Subject: Response to Comments and Questions on the Compliance Monitoring Plan/Environmental Media Management Plan, Mercer Island Property, 2885 778th Avenue SE, Mercer Island, Washington dated June 18, 2021.

On behalf of Xinghua Group Ltd (Xinghua), CDM Smith Inc. (CDM Smith) has prepared this response to comments to the above referenced memo prepared by Aspect Consulting on behalf of the City of Mercer Island (the City), dated July 27, 2021. CDM Smith completed the referenced Compliance Monitoring Plan/Environmental Media Management Plan (CMP/EMMP), on behalf of Xinghua in preparation of redevelopment work that would remove soil and groundwater impacted by petroleum hydrocarbons and/or dry cleaning solvents by past property uses.

Figure 2
Site Plan

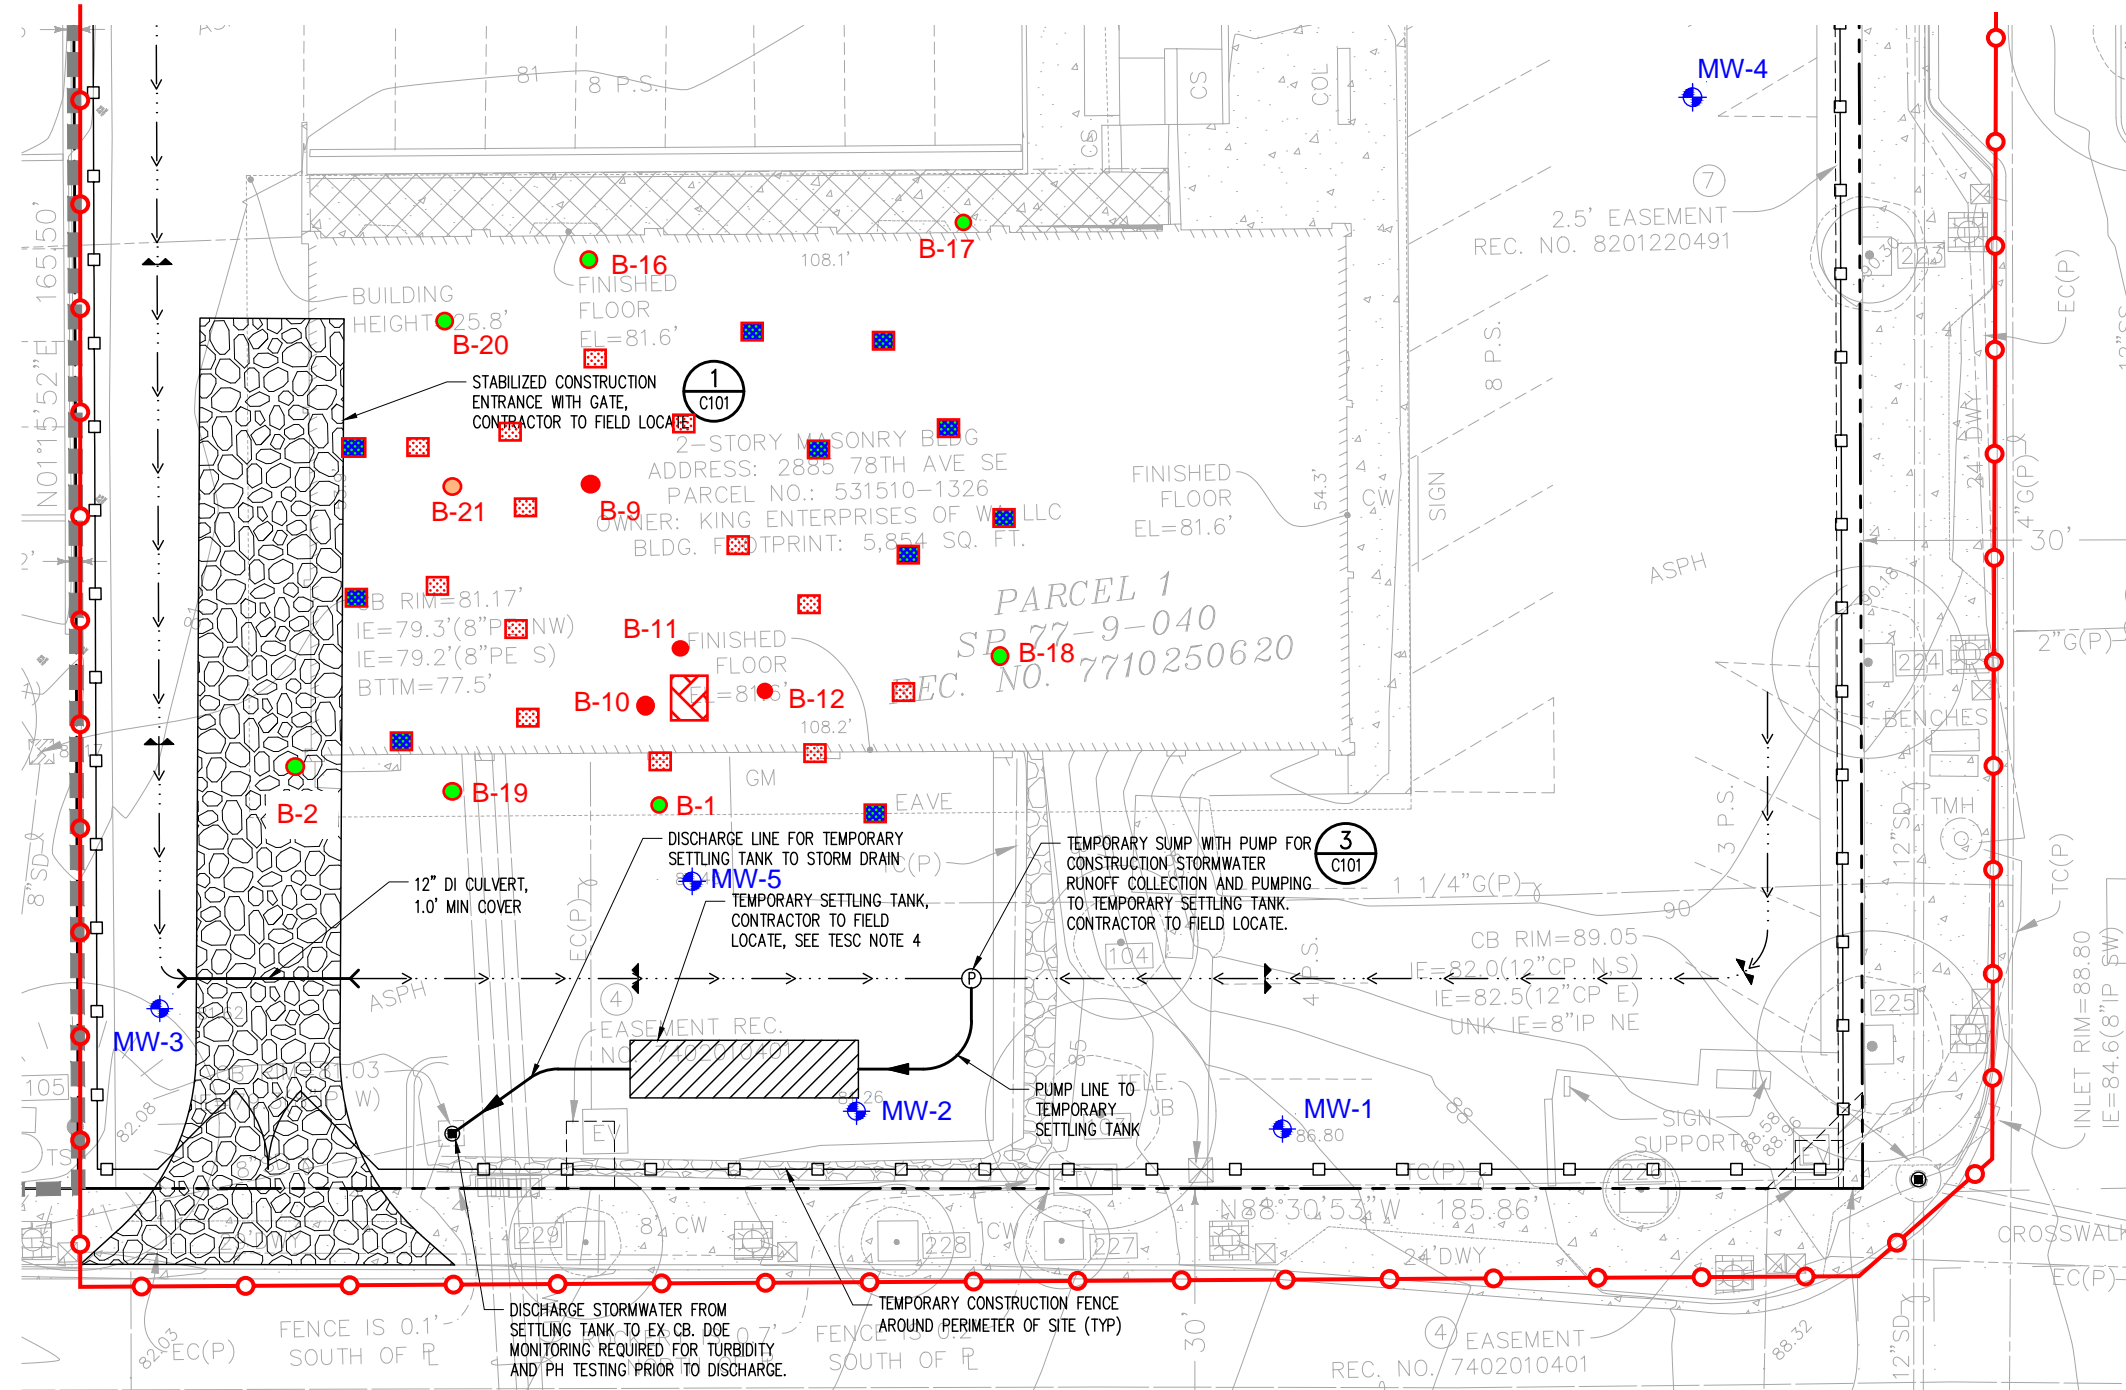
**Comment 1, Section 2.3.5:** This paragraph notes that MW3 is downgradient of the former dry-cleaning facility. However, according to Figure 2, MW3 is located southwest of the former facility, and Section 2.3.2 indicates that wells were installed to evaluate potential for contaminants migrating from the gas station to the south, implying a potential for northerly groundwater flow. Please provide additional information on the estimated groundwater flow direction and the basis of that estimate and explain how the existing data adequately bounds the extent of detectable contaminants.

**Response:** Section 2.3.2 references the Phase 1 and Phase 2 Environmental Site Assessments (ESAs) conducted in 2012. At that time, limited information was available on the hydraulic gradient for groundwater and the wells installed at the southern portion of the property were located to assess the potential for contaminant migration from the Shell station located across the street to the south, as well as to assess for potential groundwater impacts from the dry cleaning operation. Subsequent studies conducted by Farallon established the groundwater flow direction beneath the subject property. Sections 2.3.3 and 2.3.4 have been updated to provide the available information on the hydraulic gradient. Groundwater elevation contours for the site were developed using the depth-to-water measurements taken from the Site monitoring wells on September 17, 2013. The interpreted groundwater flow direction in the groundwater-bearing zone was east-southeast, with an estimated horizontal hydraulic gradient of approximately 0.0075 foot per foot. Farallon's *Summary of Subsurface Investigation Report, Mercer Island*

*Apartments King Parcel Property*, dated November 12, 2014, also developed groundwater elevation contours using depth-to-water measurements obtained from the King Parcel monitoring wells on December 8, 2013. Groundwater contours indicated a groundwater flow direction in the shallow groundwater-bearing zone to the southwest at an estimated horizontal hydraulic gradient of approximately 0.009 foot per foot, consistent with the groundwater monitoring event conducted at the site in September 2013.

Based on the downgradient position of the groundwater monitoring wells MW1 through MW3 relative to the location of the dry cleaning facility, and the fact that no groundwater samples collected from site monitoring wells have ever contained PCE at a concentration exceeding the MTCA Method A cleanup level, we consider the available groundwater data adequately bounds the extent of impacted groundwater.
